Technical Note

Project: Wicks Farm, Ford

Subject: Response to West Sussex Highways request for additional Information.

DATE	AUGUST 2019	DESIGN	BEB	DRAWN	DLW
DRAWING NO.	6352.001	SCALE	1:1000	SHEET	@ A2

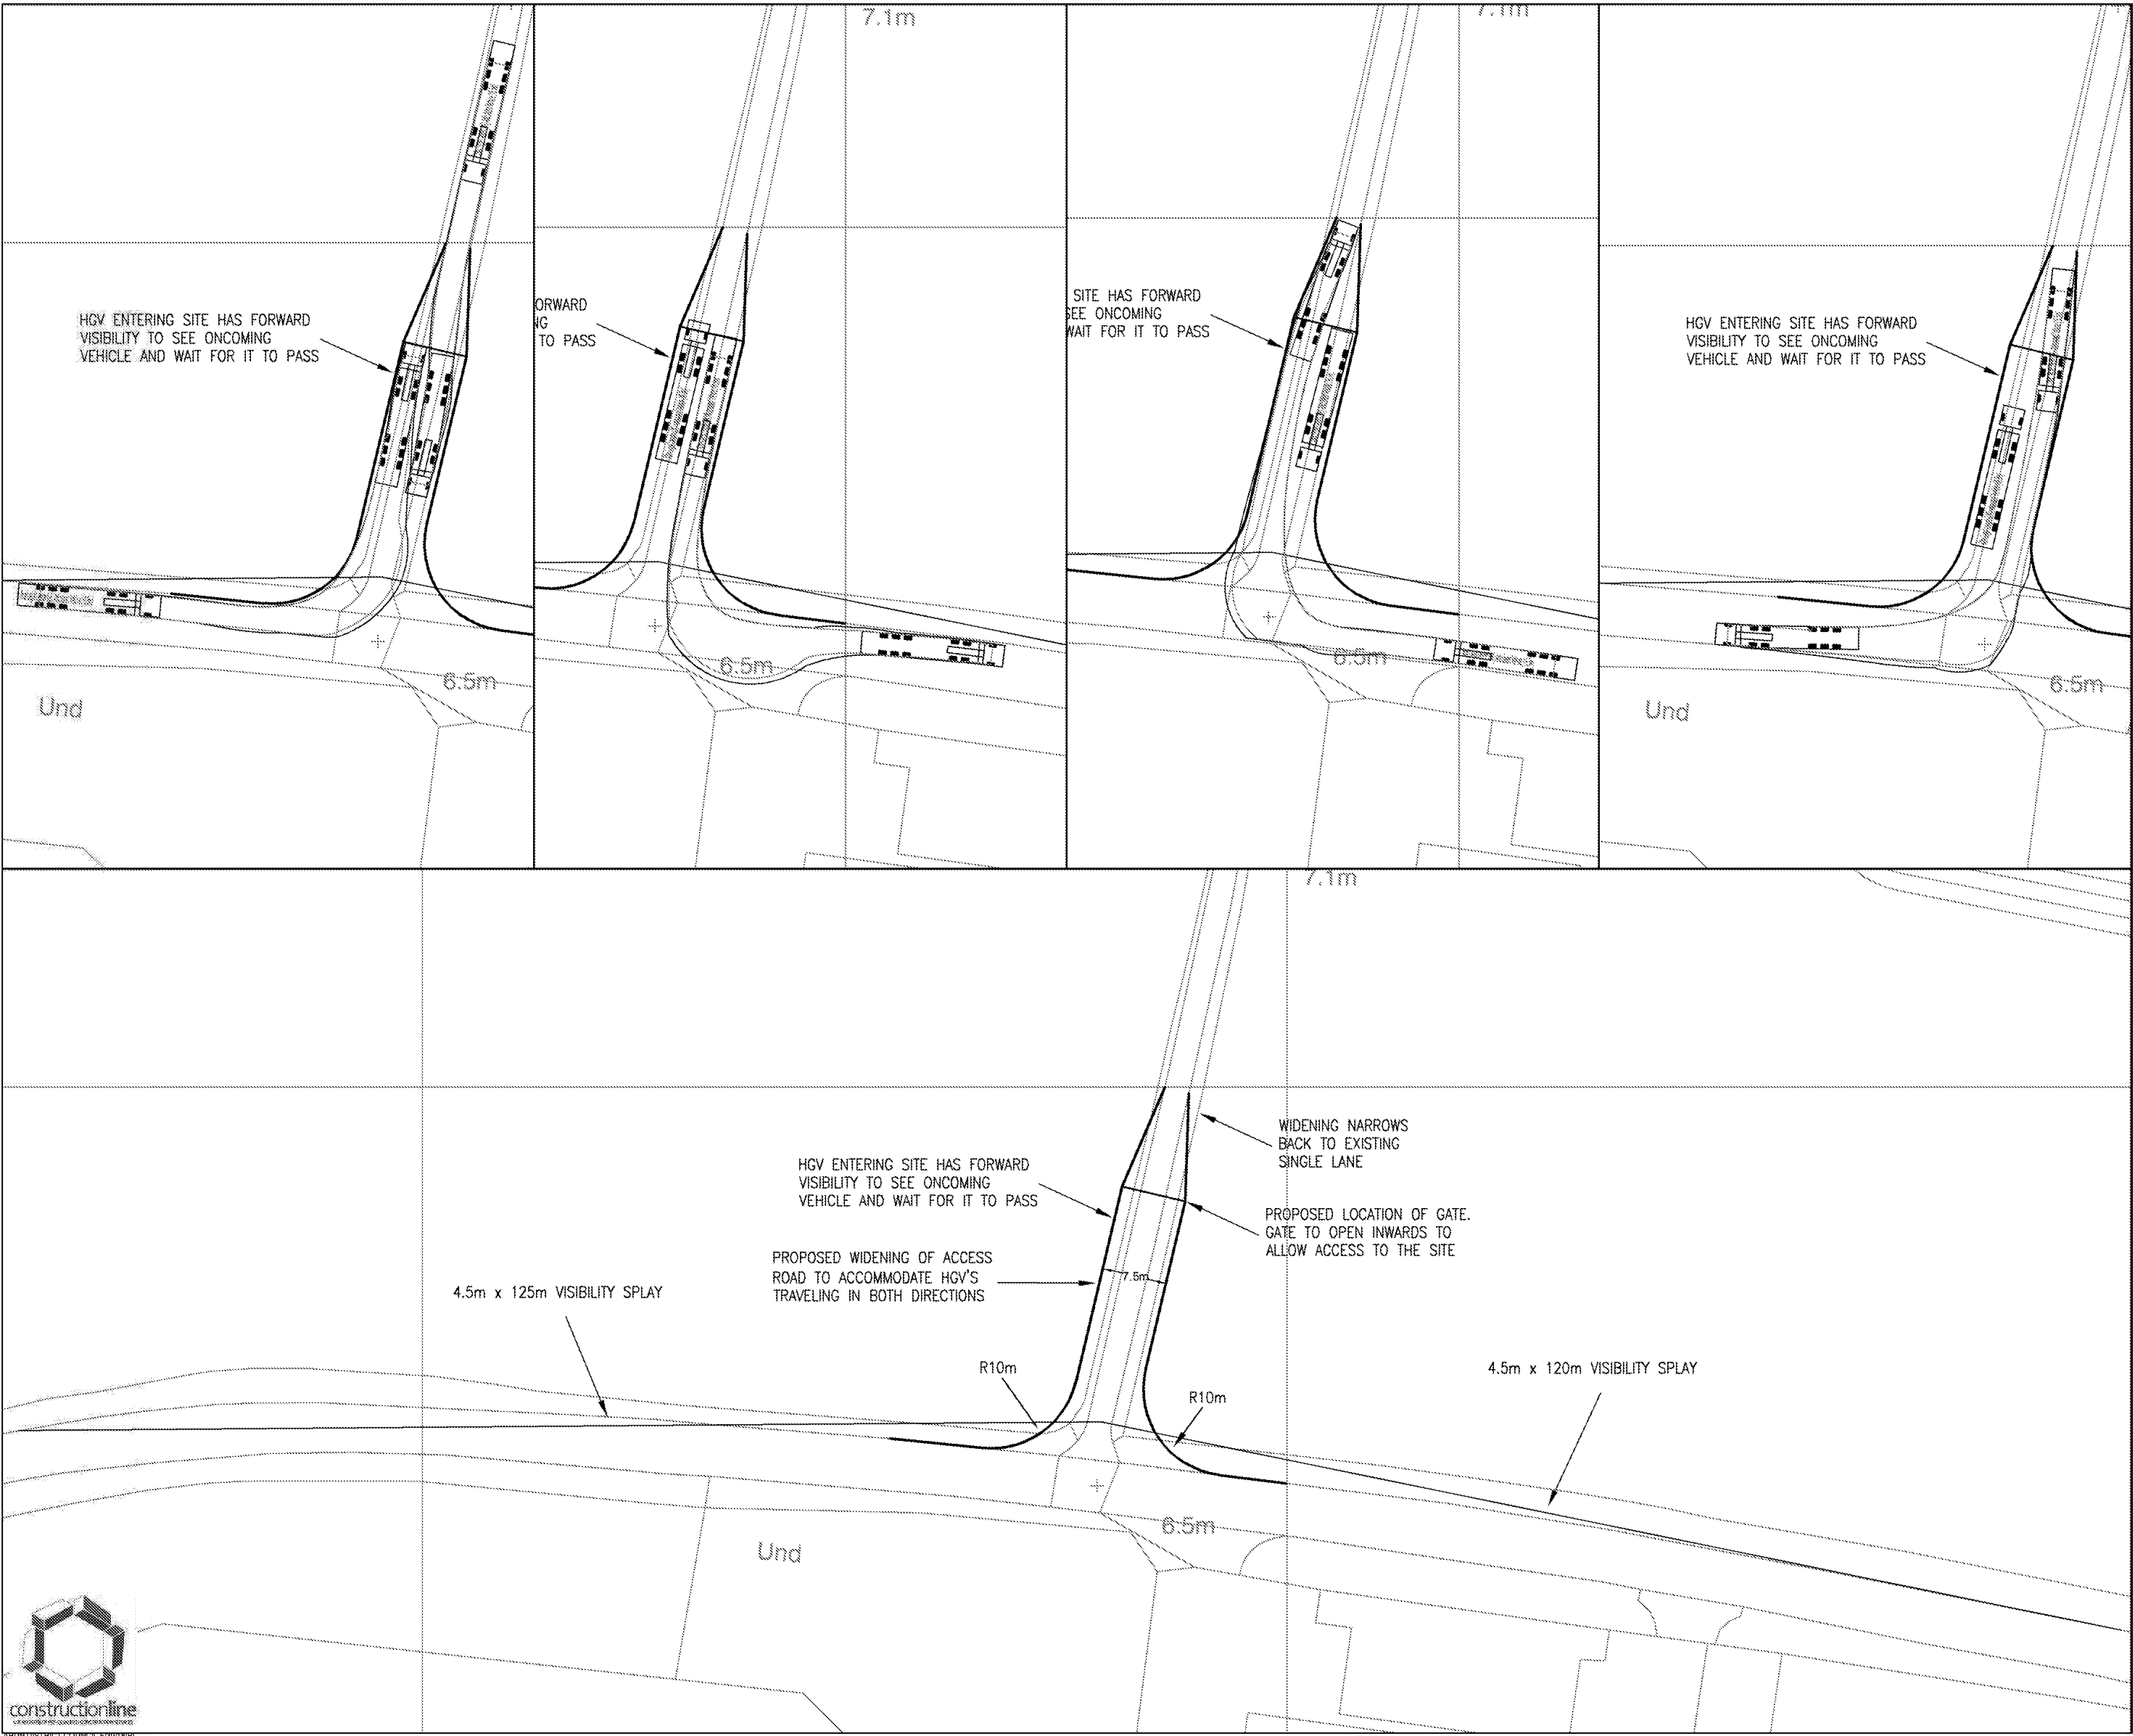
A clear plan demonstrating the current and proposed width of the access and internal access route through the site, including details of the formalisation of the access.

Swept path tracking demonstrating the largest anticipated vehicle entering the site, travelling through the site, turning and exiting the site.

A seven day speed survey should be undertaken to determine 85th percentile speeds in this location. Visibility splays should be provided in accordance with these speeds.

- 1.10. The site will take access from an existing farm track with a junction onto Ford Lane. This access is currently not suitable for HGV's and will need to be improved in order to facilitate HGV movements for the development. SMA has undertaken a review of the existing access and has suggested a redesigned access solution, as shown in **Drawing 6352.001**.

- 1.11. The junction design shown in **Drawing 6352.001 Rev A** shows, the access will be widened to 7.5m for the first 30m before narrowing back down to the existing width for the remainder of the length of the access road.

- 1.12. A hardened surface will be provided over the first 10m of the track and the access regraded over this distance to provide a maximum gradient of 4%, which is suitable of HGV's to access.

- 1.19. The wet weather speeds are therefore used as the basis of the visibility splays for the proposed site access. The proposed visibility splays are therefore 125m on the westbound carriageway and 120m on the eastbound carriageway. These visibility splays are shown in **Drawing 6352.001 Rev A**.

- 1.21. As **Drawing 6352.001** shows, there is no obstruction to the visibility splays in either direction from the access.

LONGITUDINAL PROFILE BETWEEN DRIVER EXITING PROPOSED SITE ACCESS AND ONCOMING DRIVER TO THE WEST OF THE SITE ACCESS
(FROM A TO B, REFERENCE PLAN ABOVE) ALONG THE 125m INTERVISIBILITY ENVELOPE

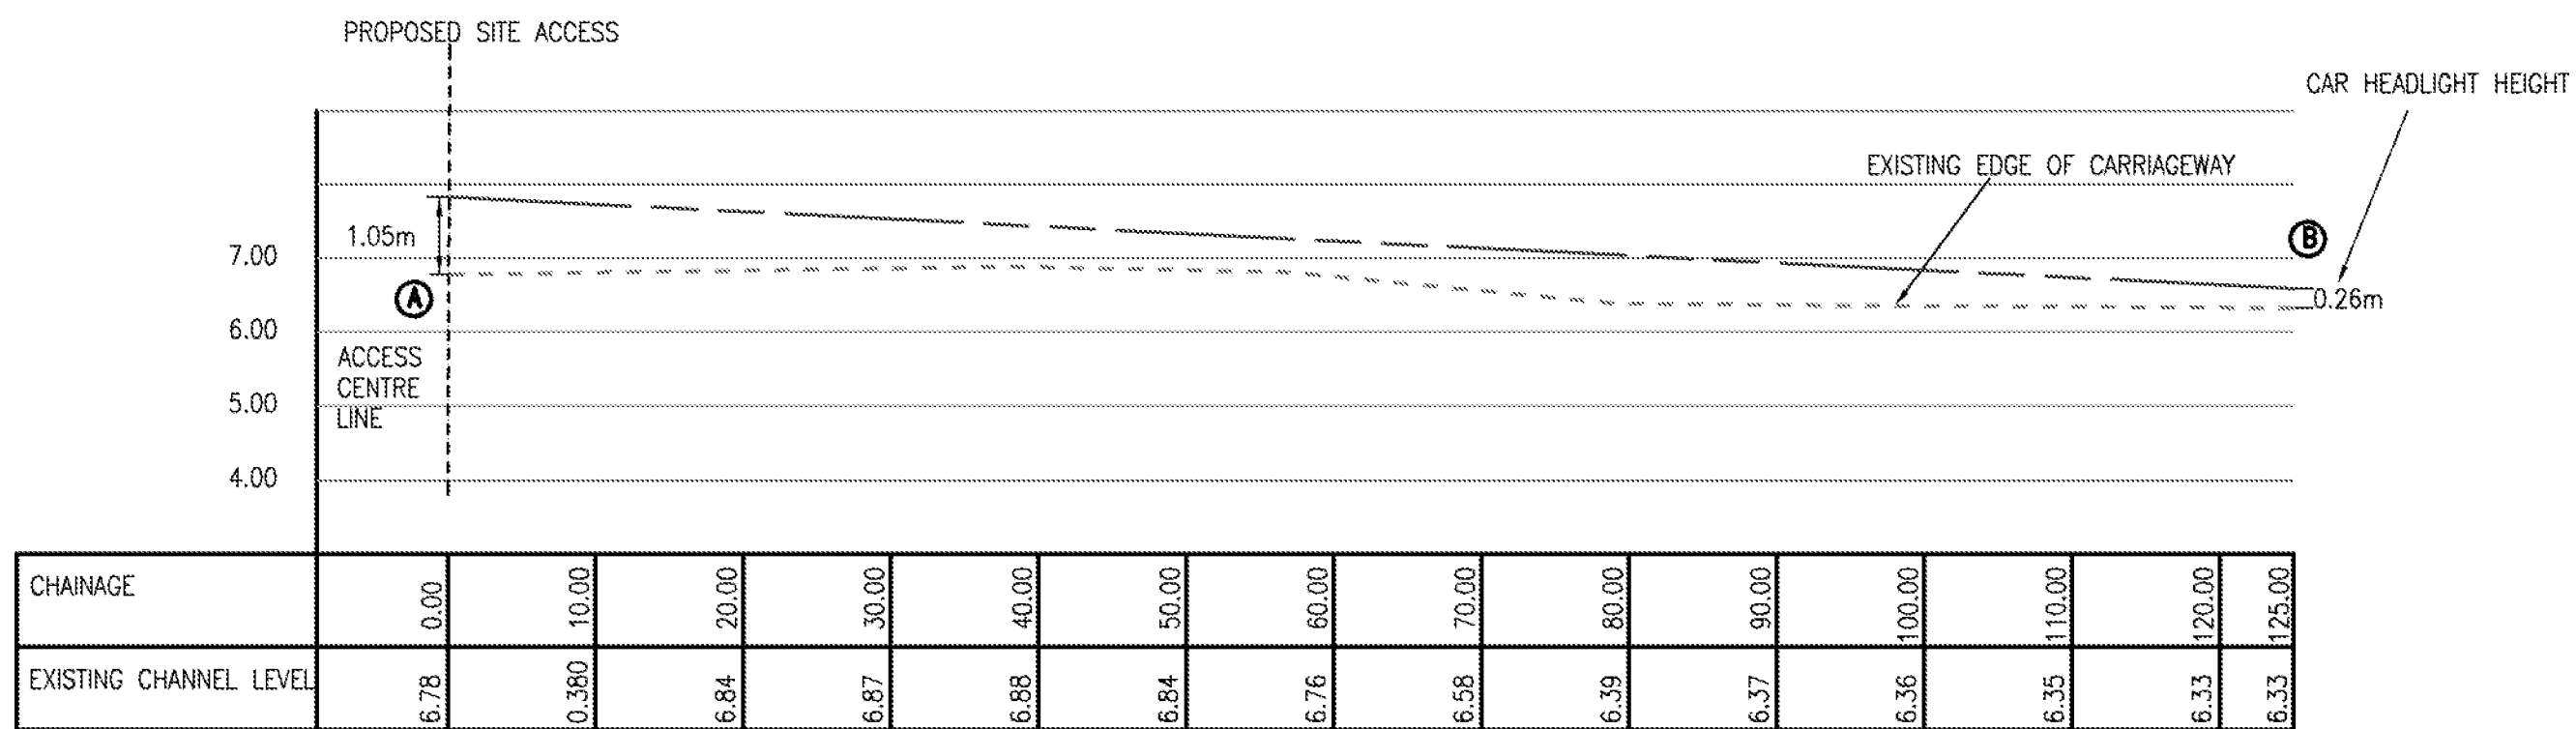
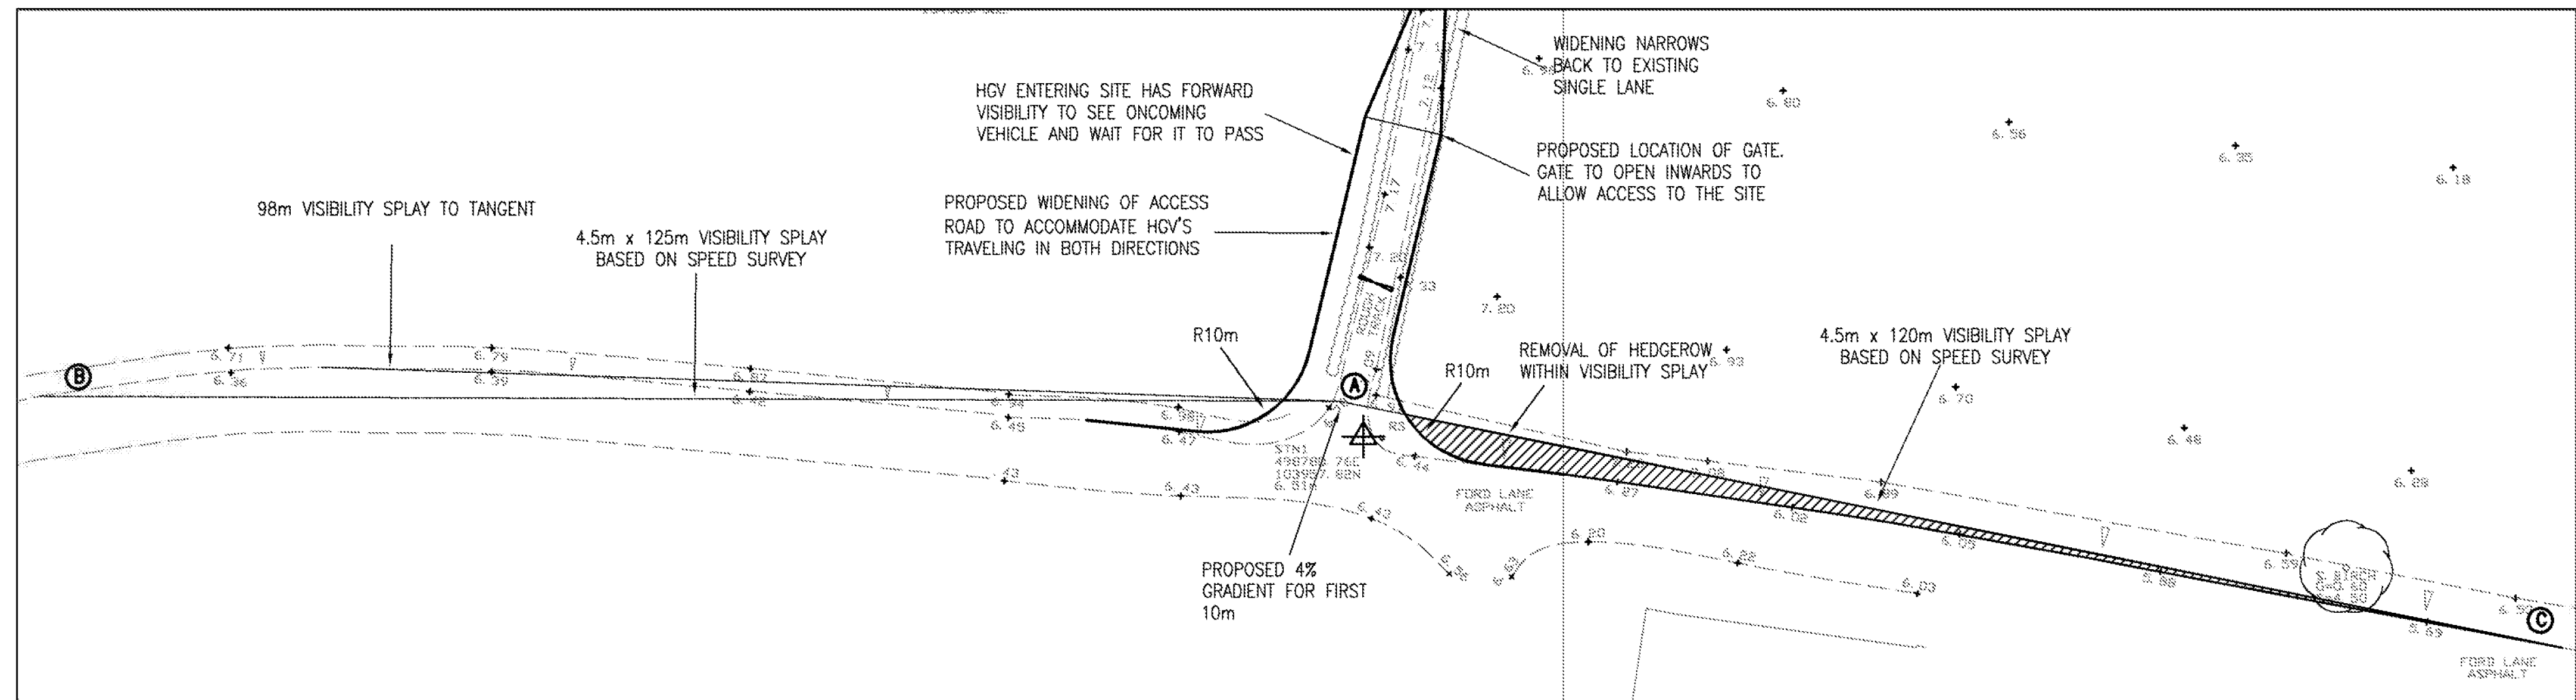
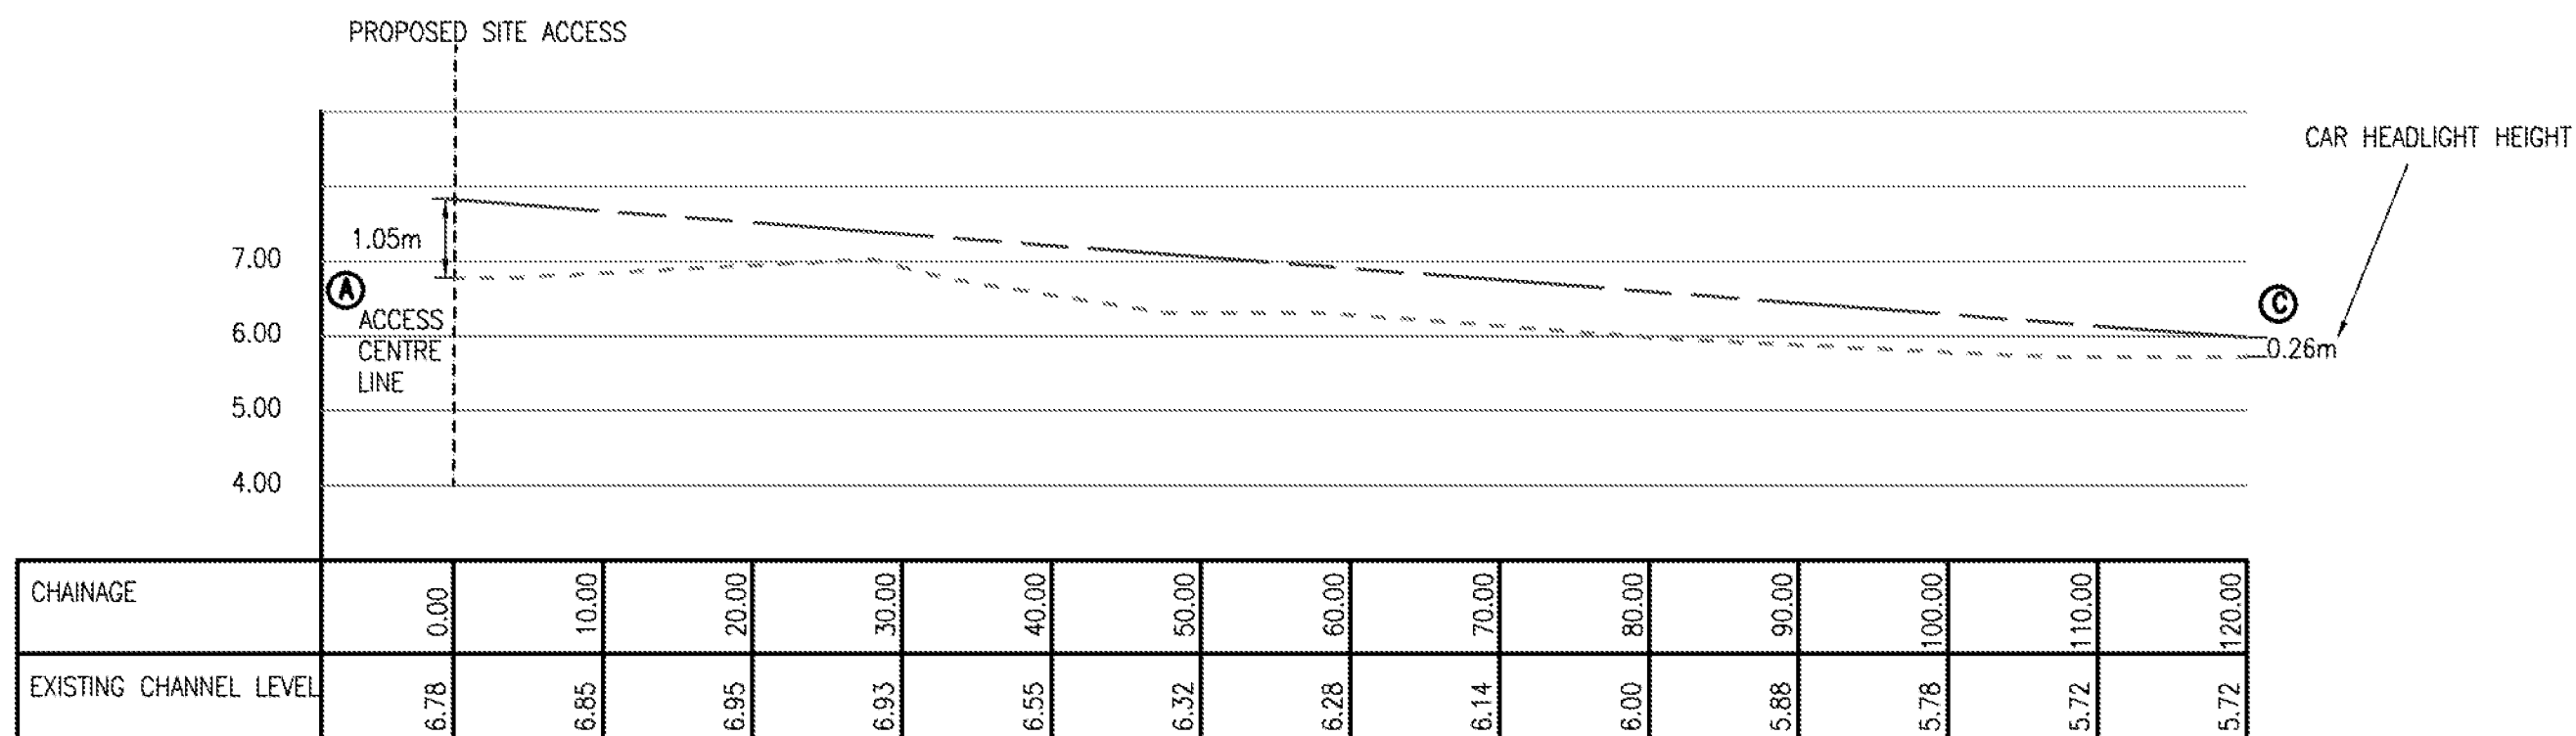
Vertical visibility at a distance of 4.5m back into the access for the full length of achievable vehicular visibility splays.

- 1.20. **Drawing 6352.004** considers the vertical profiles of the visibility splays from the proposed site access, based on the results of the speed survey. The vertical profiles measures 1.05m above ground height, this is the height where a driver's eye is agreed to be, to the height of a car headlight 0.26m from the ground level.

- 1.33. Based on a speed survey commissioned by SMA, visibility splays of 120m eastbound and 125m westbound have been deemed appropriate for the proposed access. These have been based on wet weather speeds, formulated using DMRB standards. The vertical profile of these visibility splays has been investigated and no obstructions requiring works to rectify were found.
